5-lot Subdivision

**Project Name:** 5-Lot Subdivision Plymouth St.  
**Project ID:** 09-98900001  
**CBL:** 345 - B-009-001  
**Project Address:** 119 PLYMOUTH ST  
**Planner:** Eric Giles, AICP

## PLANNING BOARD REPORT#29-09 PORTLAND, MAINE

LAND OF W.A. ONE, INC  
119 PLYMOUTH ST.  
SUBDIVISION  
98900001  
DIVERSIFIED PROPERTIES, LLC, APPLICANT

Drawing No. **C101**

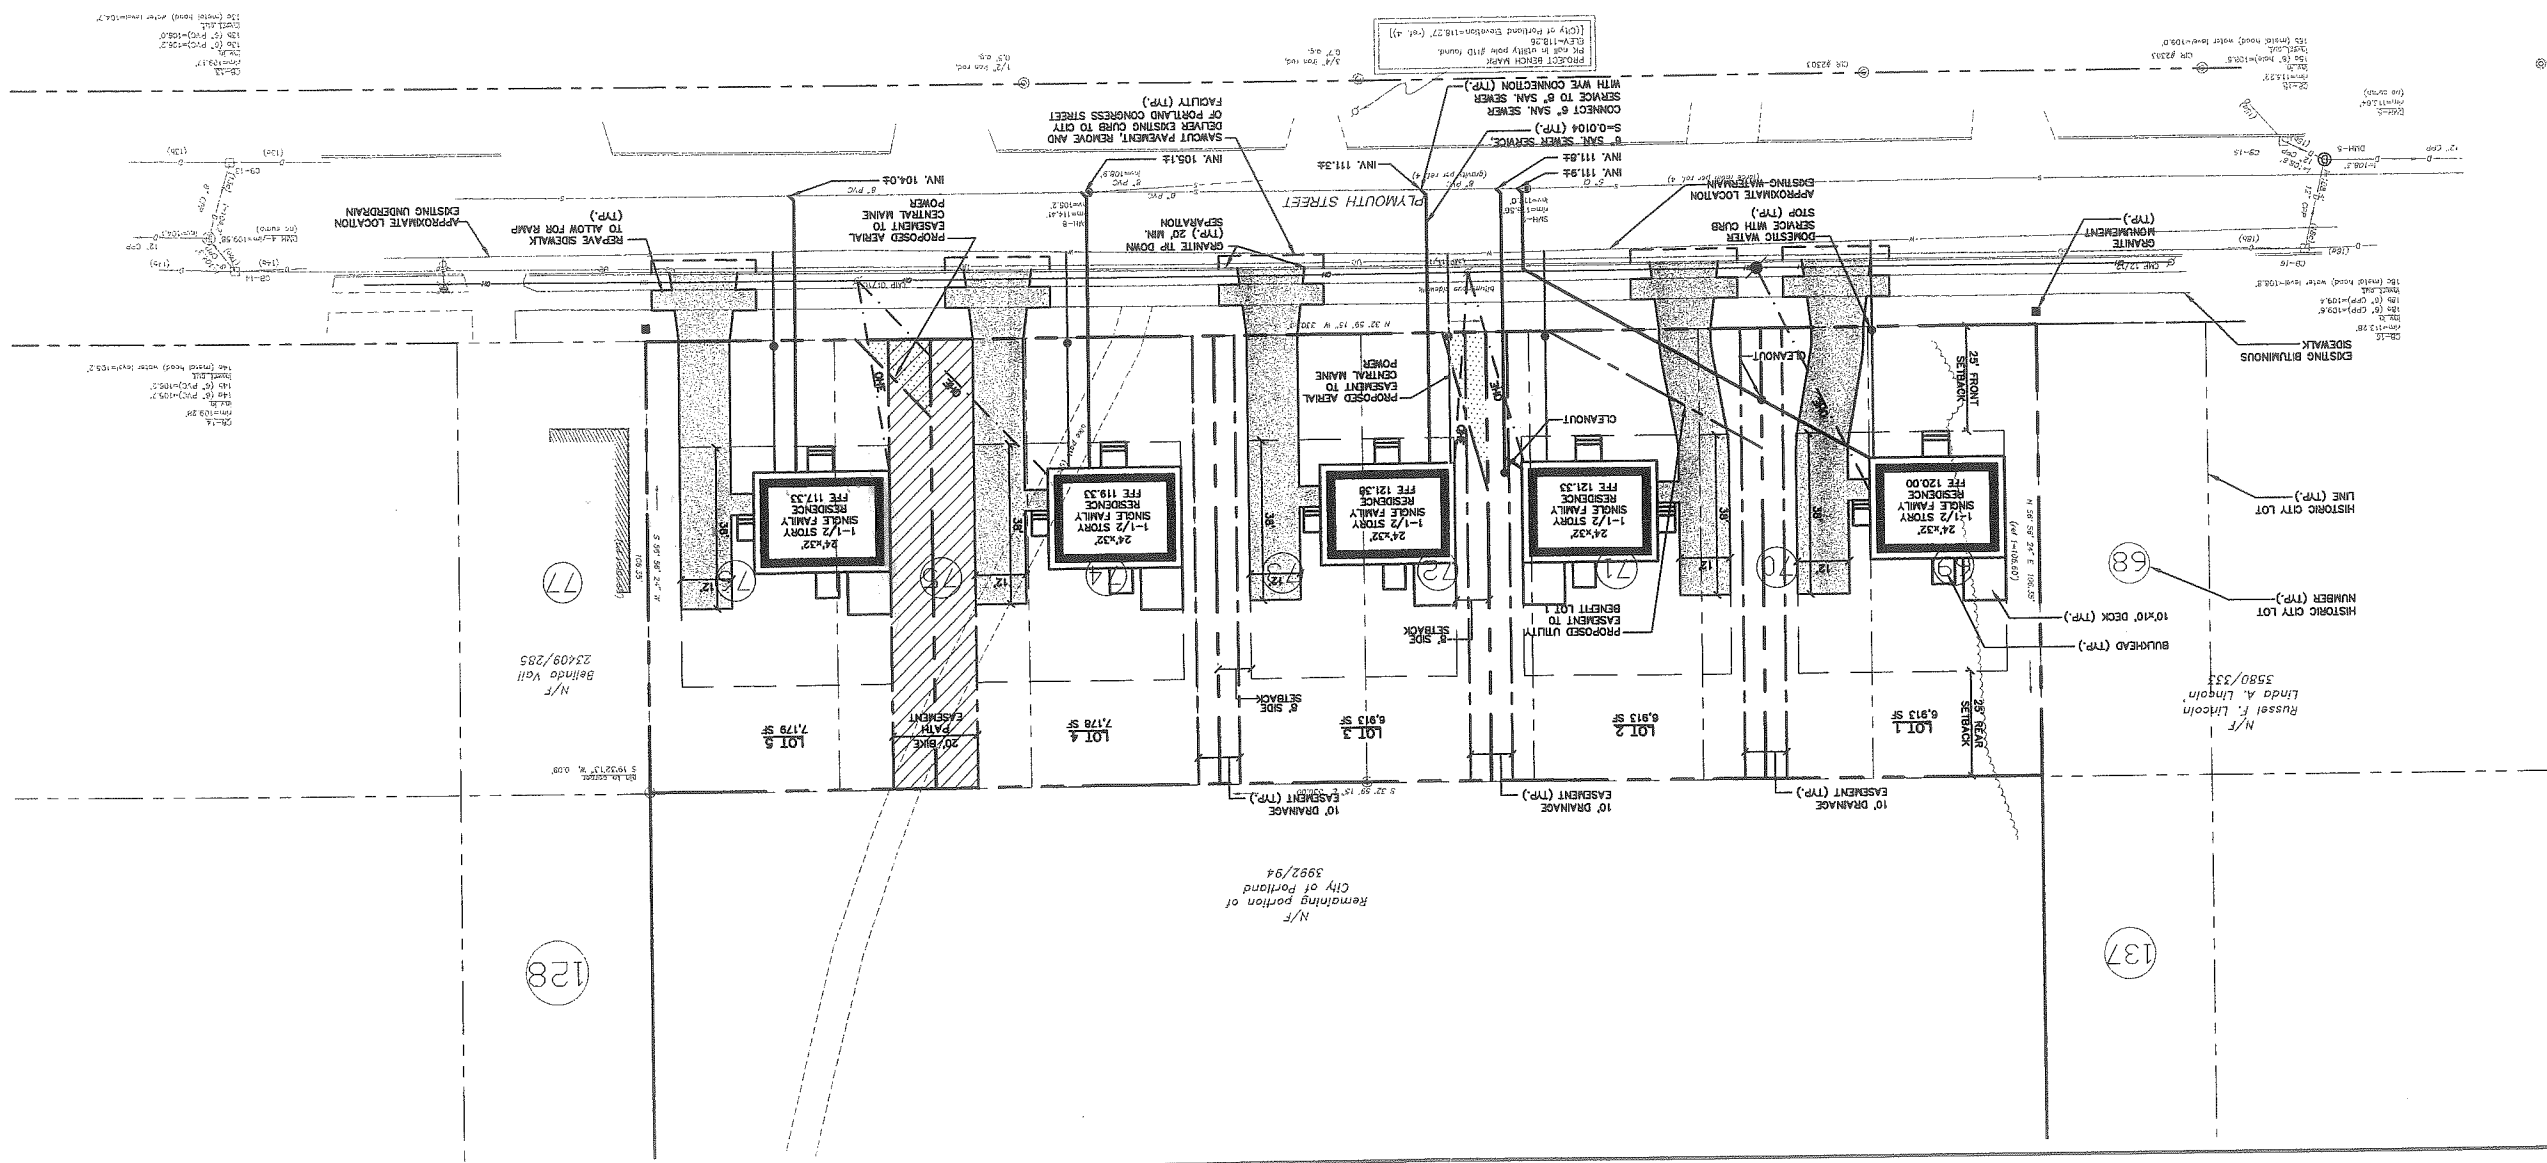
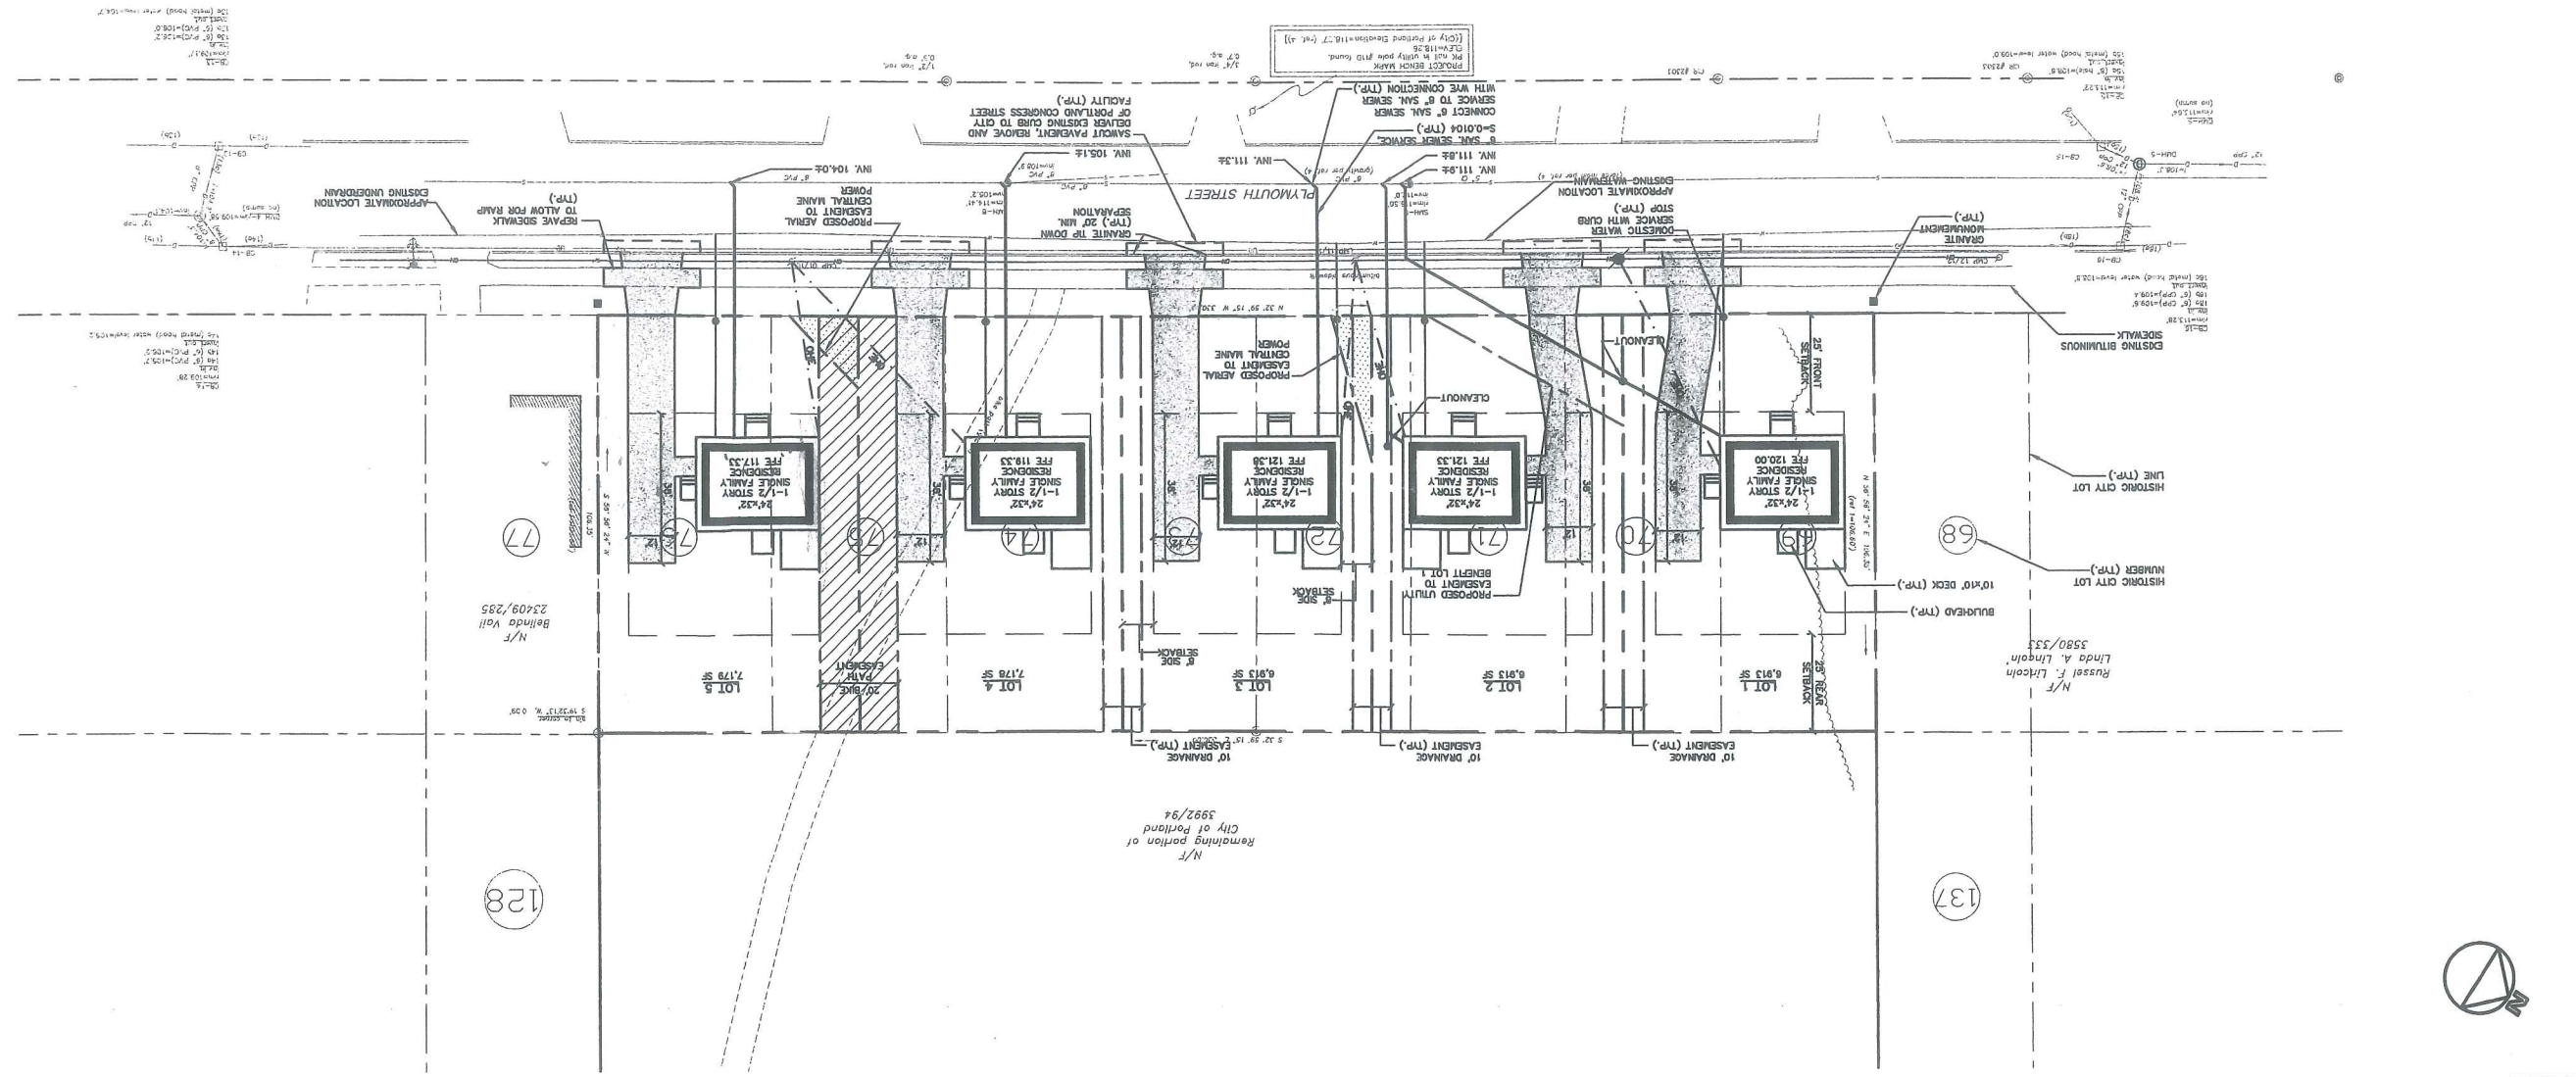
2. The applicant shall submit a revised sheet C101 relocating the building and driveway on Lot 5 from the easterly side to the westerly side with grading revisions and a buffering plan along the trail for review and approval by the Planning Authority.

06/11/09 – Driveways and building pads on Lots 4 and 5 should be reversed to show driveways abutting trail easement. The applicant has submitted a revised site plan in accordance with this recommendation.
